Re Planning Application: P/58/15/OUT

20th August 2015

We strongly oppose above application for the following reasons:

Figure 18 - Proposed Summer Lane/Pagham Road Junction

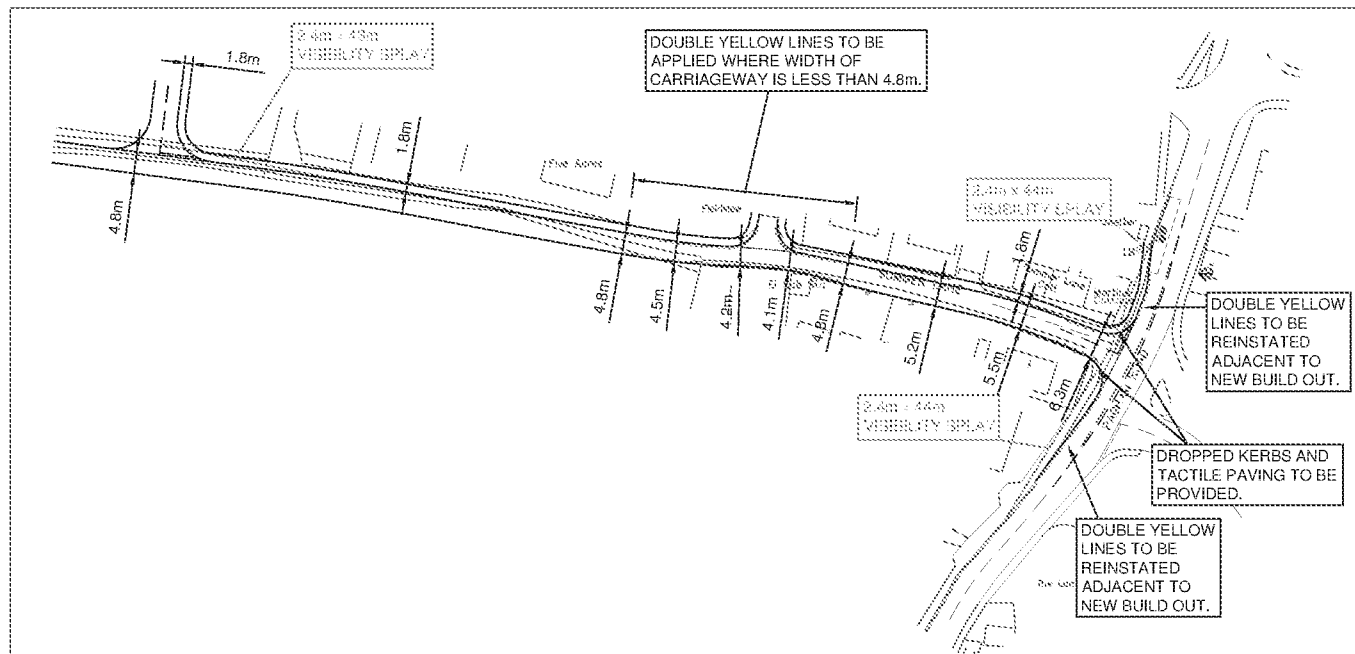
(iii) **Site Access Plan Drawing N0.120843/A/11**

The plan indicates on both sides of the road there will still be protected on-street parking.

Cars are currently parked in existing bays nearly always. This constantly reduces the access/exit to Summer Lane to effectively single lane access.

(v) Site Access Plan Drawing N0.120843/A/11

The yellow 'no parking' lines indicated around the east access point will not prevent parking by cars displaying blue badges. Cars so parked in these narrow sections of Summer Lane will simply add to the burden and consequential chaos caused by additional significant traffic volumes. The same applies to cars illegally parked on yellow lines. With additional cars and limited parking in the immediate area serving the local shops, it will only exacerbate illegal parking.

(vi) Parts of the revised road width will be too tight for safe traffic flows especially in regard to daily large commercial vehicles referred above, plus emergency services. See Appendix C below
